DRB Project# 1002626 Subdivision Name VNM/T-VI Parking Area, Tr A

14. **Project # 1002626**  
03DRB-00680 Minor-Prelim&Final Plat  
Approval

**RE : Unplatted Lands of the Regents of UNM**

Re: Request for Internal Routing – Minor Subdivision / Final Plat Approval  
**REVISED** Plat of Proposed Tract A, UNM / T-VI Parking Area  
(DRB Project No. 1002626)

**PLAT OF  
TRACT A, UNM/T-VI PARKING AREA**  
ALBUQUERQUE, BERNALILLO COUNTY, NEW MEXICO  
APRIL, 2003

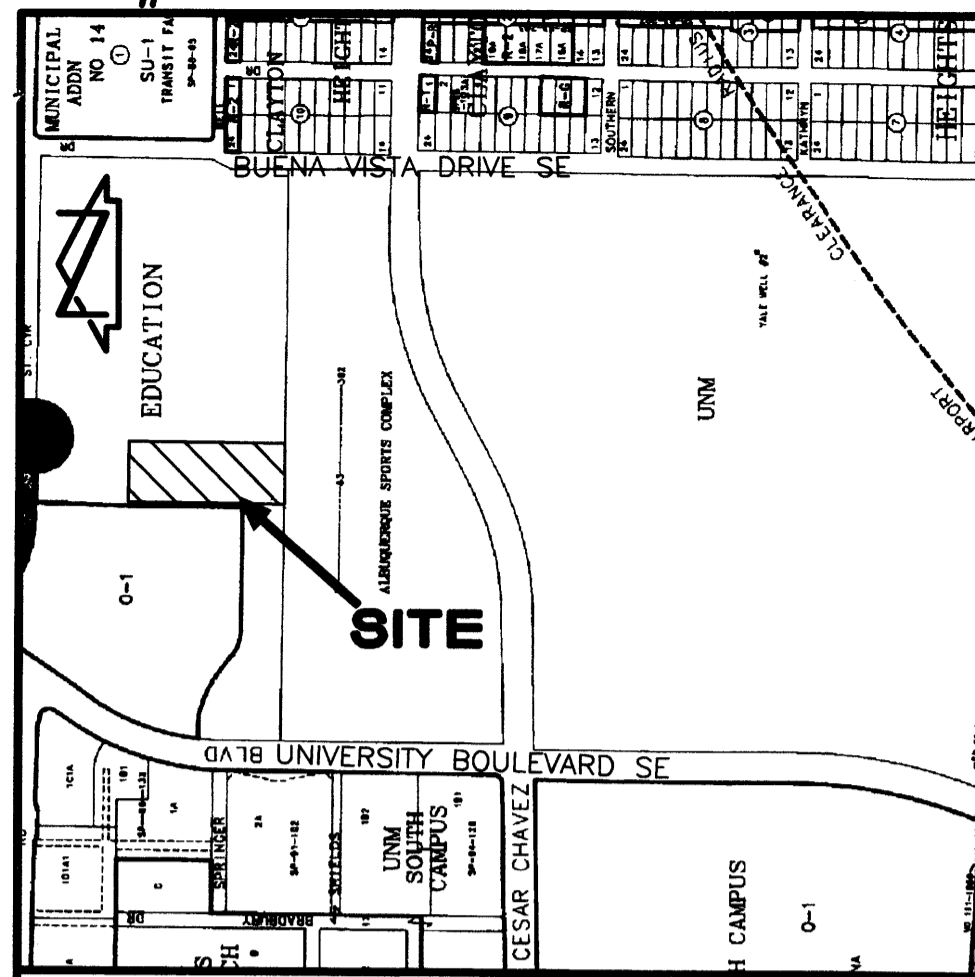
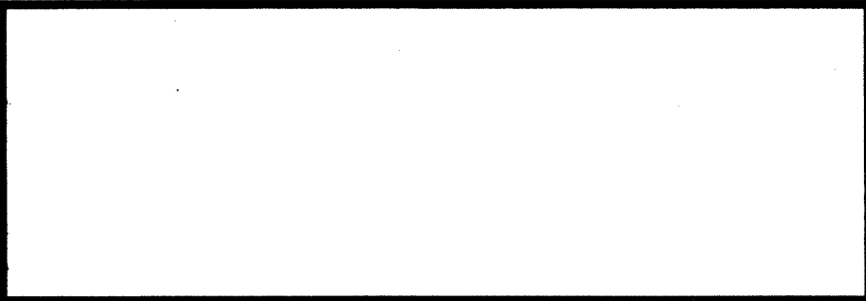
This property has no legal drainage or access easement. However, it is part of a masterplan of TV-I and all drainage facilities are in place. Therefore, only a downstream drainage easement is required for this platting action.

No.	Comment
▪	Access needs to be provided to this parcel.
